Application Reference: 2024/1072

Site Address: 31 Mill Hill, Wombwell, Barnsley, S73 8SJ

Introduction: This application seeks full planning permission for a Single storey side and rear extension to 2 storey semi-detached dwelling

PROPOSED REAR ELEVATION
SCALE 1:100

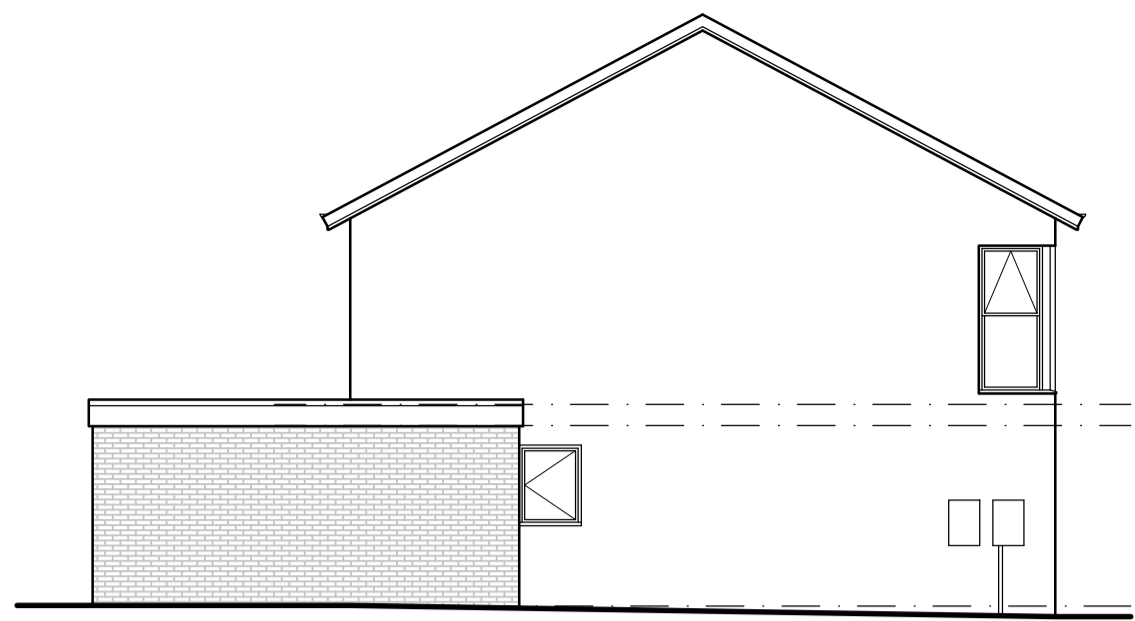
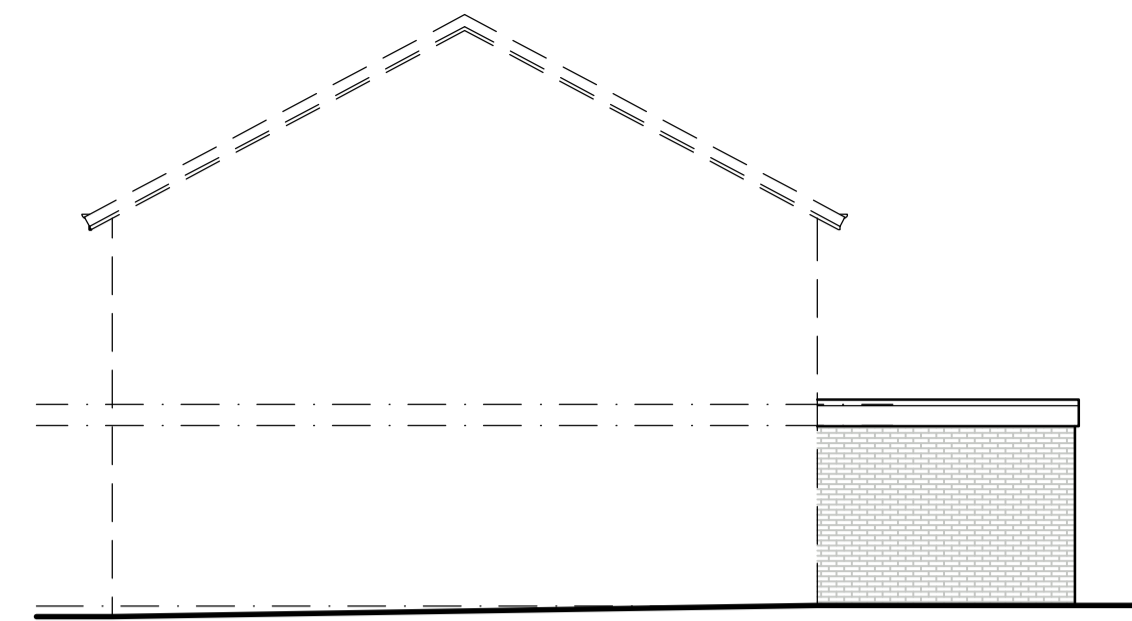
With a 3.3m side projection, 4m rear projection (from the rear elevation), an eaves height of 2.25m, and ridge height of 3.75m, the proposal does broadly meet the size guidance outlined with the House Extensions and Other Domestic Extensions SPD.

Starting with the adjacent Neighbouring dwelling of No32, whilst a 45-degree angle from their kitchen window on the rear elevation is not breached, the extension does feature a rear

projection of 4m, 1m more than would be allowed by permitted development. However, with the eaves and ridge heights of the roof being 2.25m and 3.75m respectively, both measurements are below the maximum height allowable by permitted development and are within the SPD guidance. When considered in conjunction with an approximate 2.5m distance between the side elevation of the extension and the reasonably strong boundary treatment between the attached dwellings, the impact on amenity of the neighbouring dwelling would be little or none.

PROPOSED GROUND FLOOR PLAN
SCALE 1:50

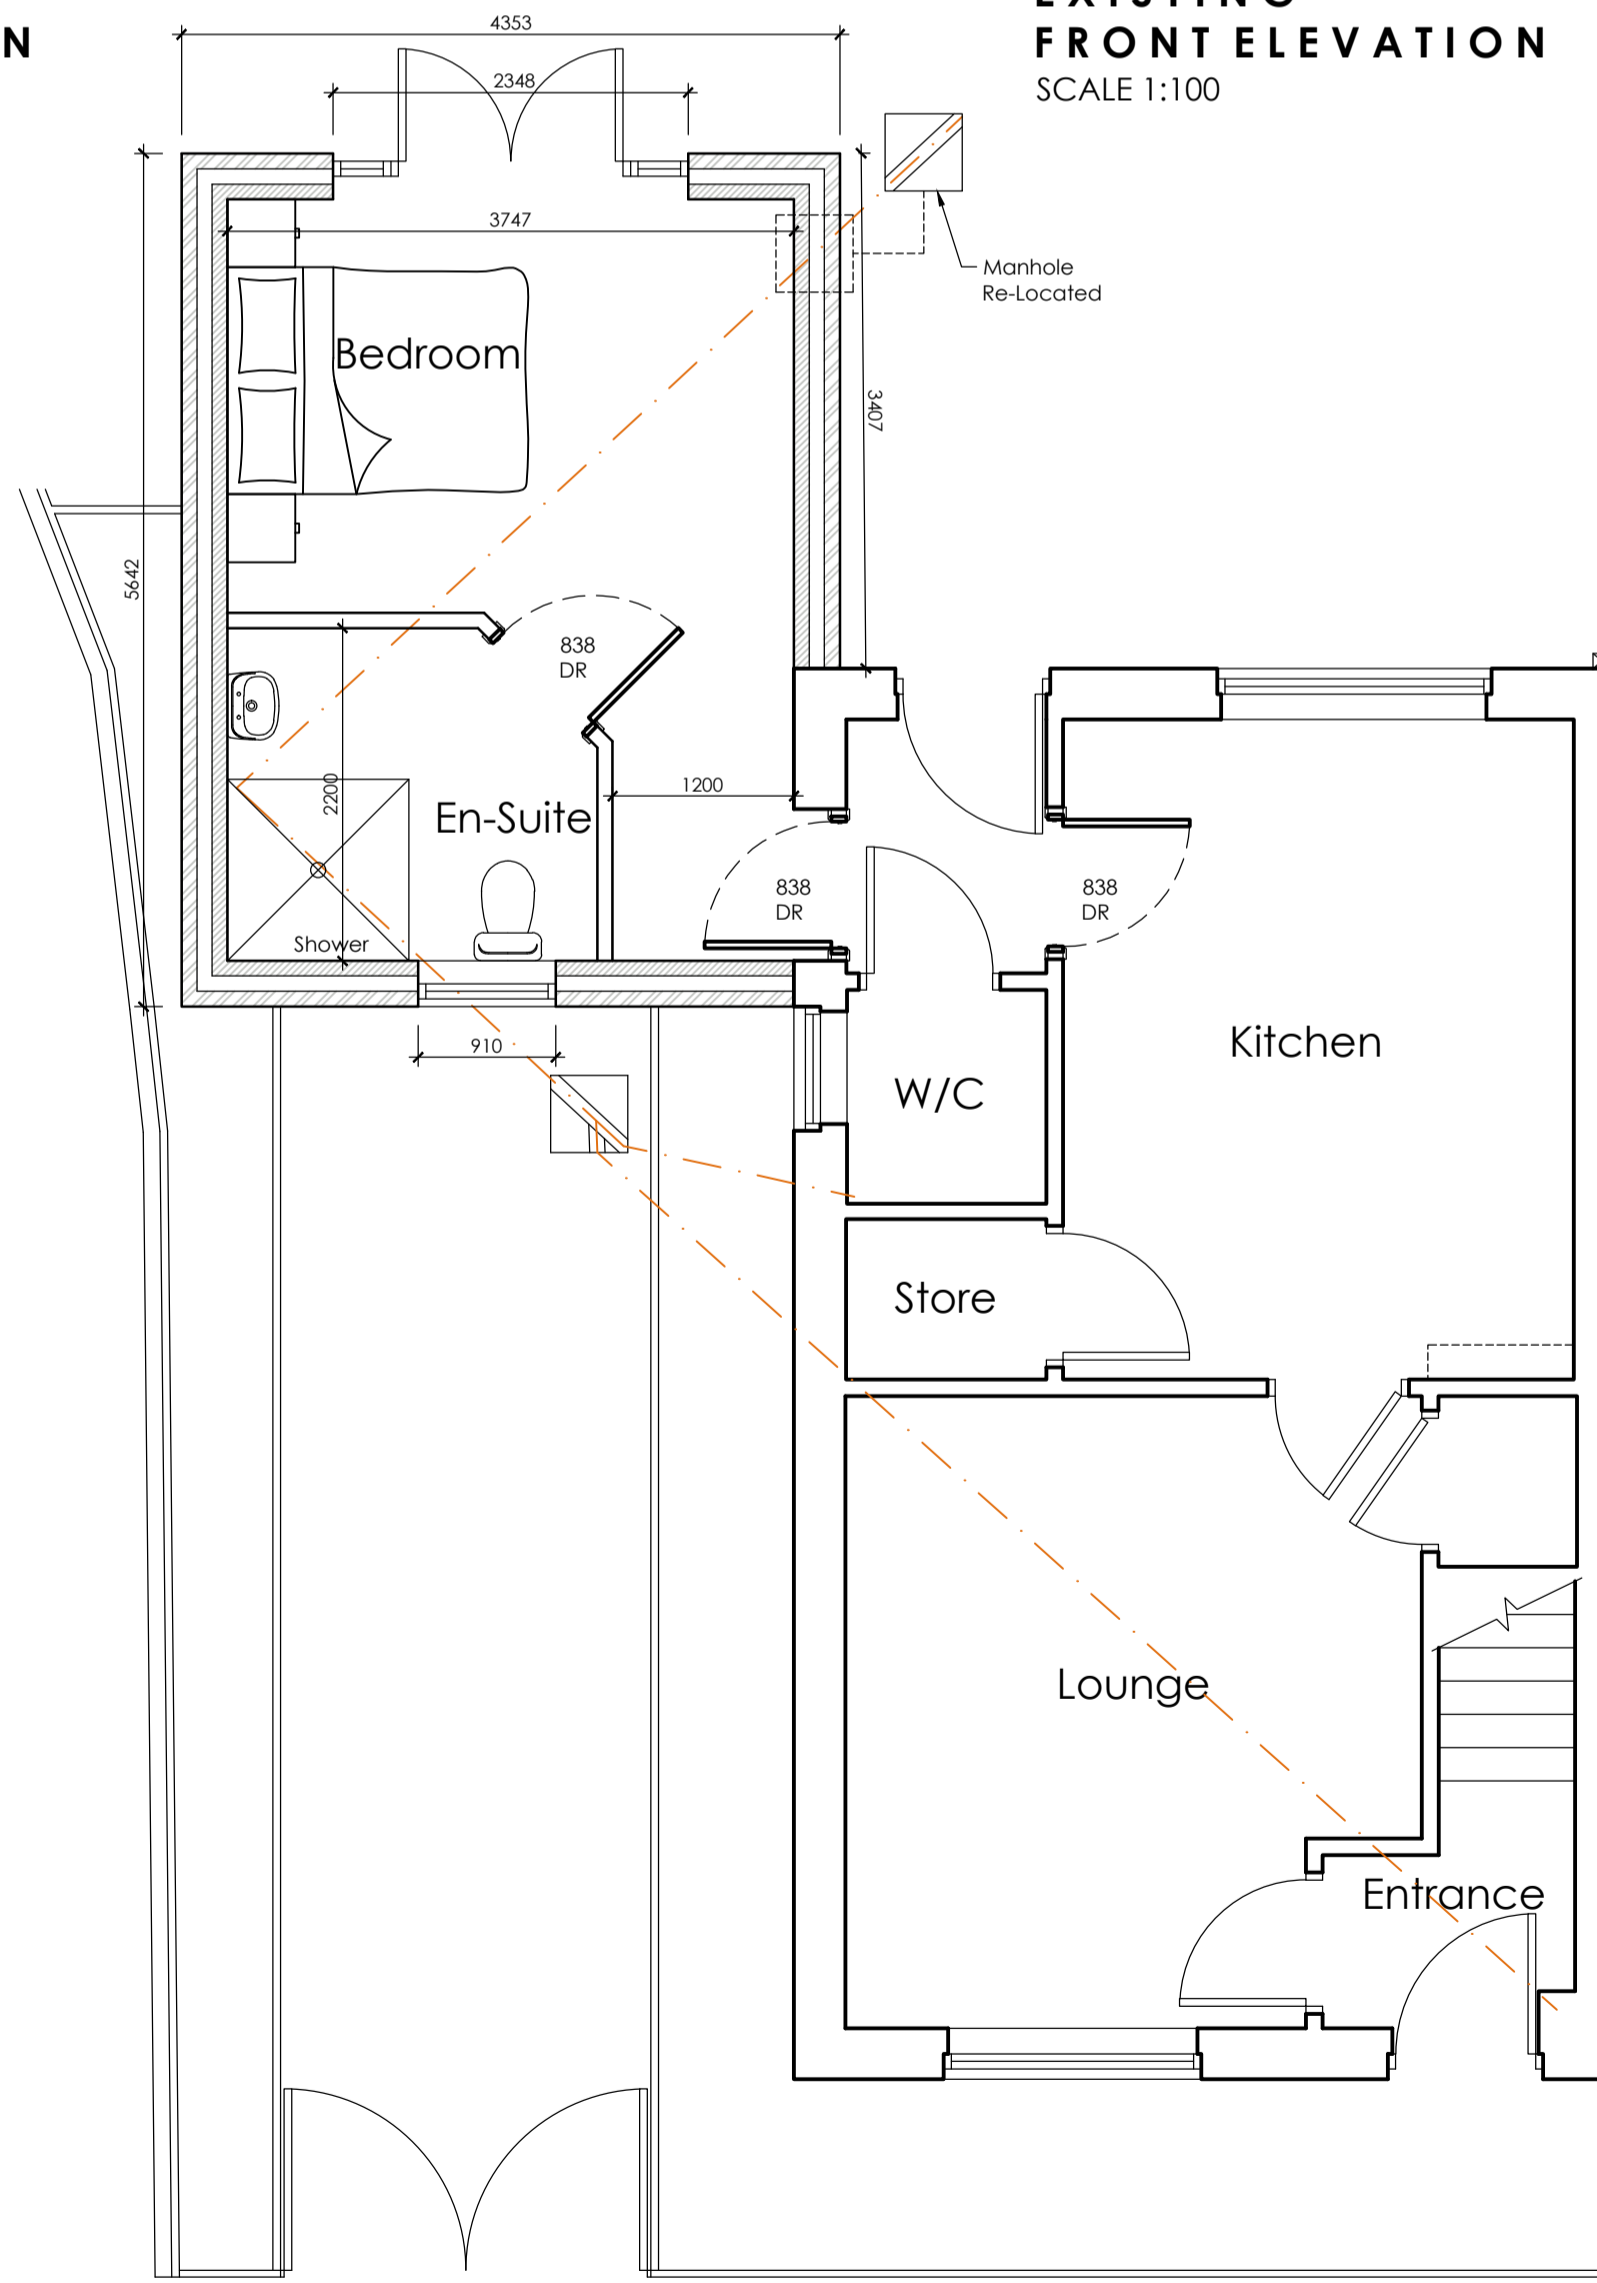
The proposal has been amended from that original proposed for a side extension, to a single-storey side and rear wraparound extension, set further back within the existing driveway to allow for retained parking provision.

For the original proposal, concerns were raised over the impact of the proposal on the existing parking provision at the dwelling. Following assessment of revised plans, the objection has been withdrawn subject to the installation or retention inward opening gates for the lifetime of the development.

- The initial proposal did not leave a satisfactory amount of in-curtilage parking provision and received an objection from Highways DC.

Following an initial objection, the proposal, subject to the specific installation or retention of inward opening gates, would now be acceptable and not have a detrimental impact on parking provision or highway safety.

4. Any gates shall be hung so as to only open inwards and be permanently retained as such for the lifetime of the development.
Reason: To ensure the safe and unobstructed use of the adopted highway is maintained in accordance with Local Plan Policy T4 New Development and Transport Safety.
-
